Harnett County Government Complex
307 Cornelius Harnett Boulevard
Lillington, NC 27546

**Re: Status of Improvement Permit Application #08-5-19917
Shawn & Stacey McCracken**

On May 15, 2008, a second attempt was made to evaluate your property for the purpose of issuing an Improvement Permit. The evaluation could not be completed for one or more of the following reasons.

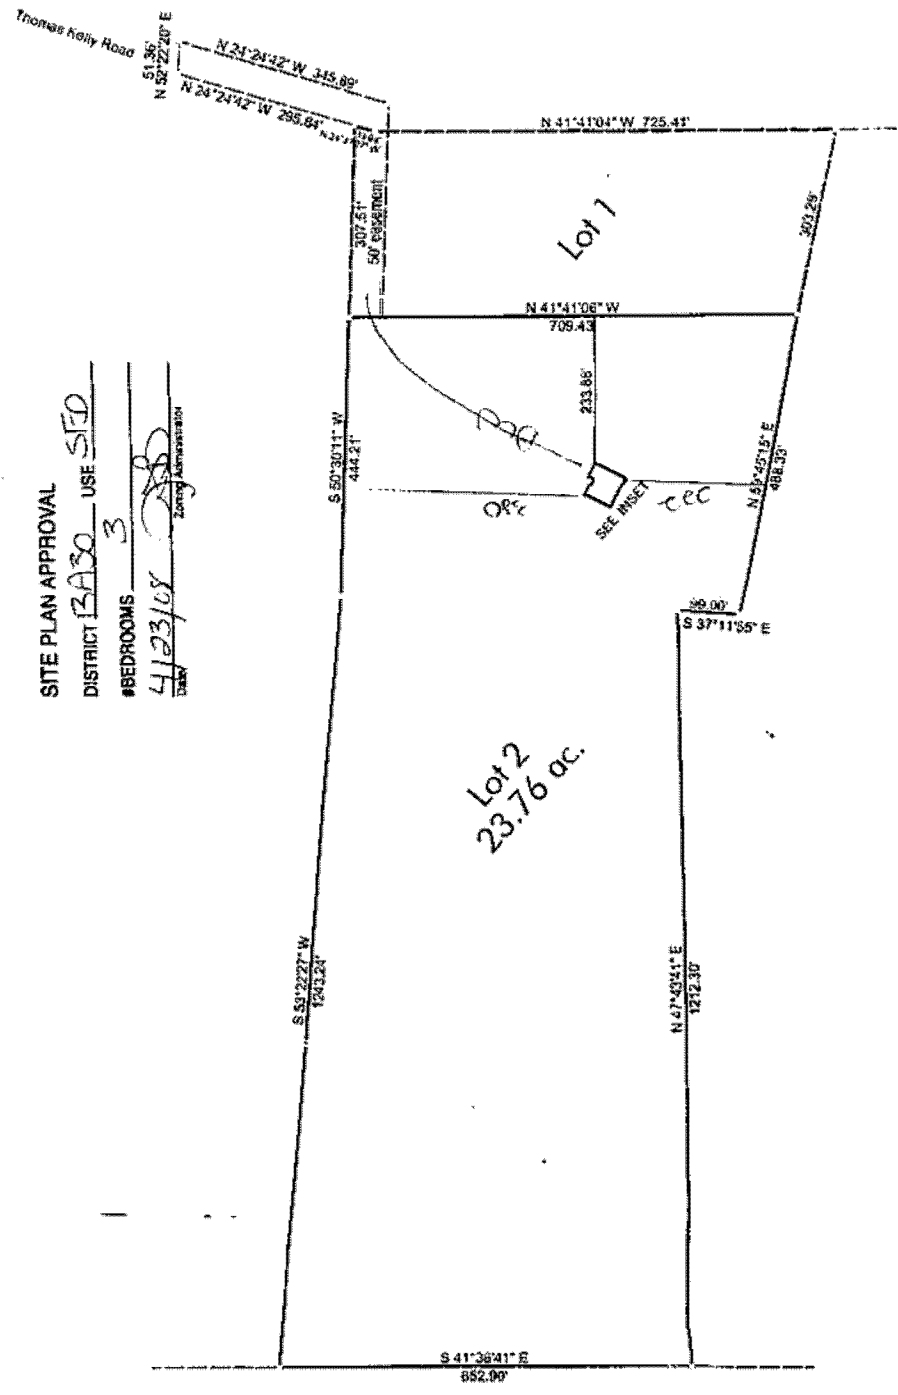
- 1. Property lines/corners not marked or labeled
- 2. House corners not marked or labeled
- 3. Directions not clear to property
- 4. Property needs brush or vegetation removed
- 5. Backhoe pits required
- 6. **Other – Move home as shown and submit new plot plan to Central Permitting.**

Existing Home

Howe howe to be outside
Area shown AS SEPTIC or Repair Area
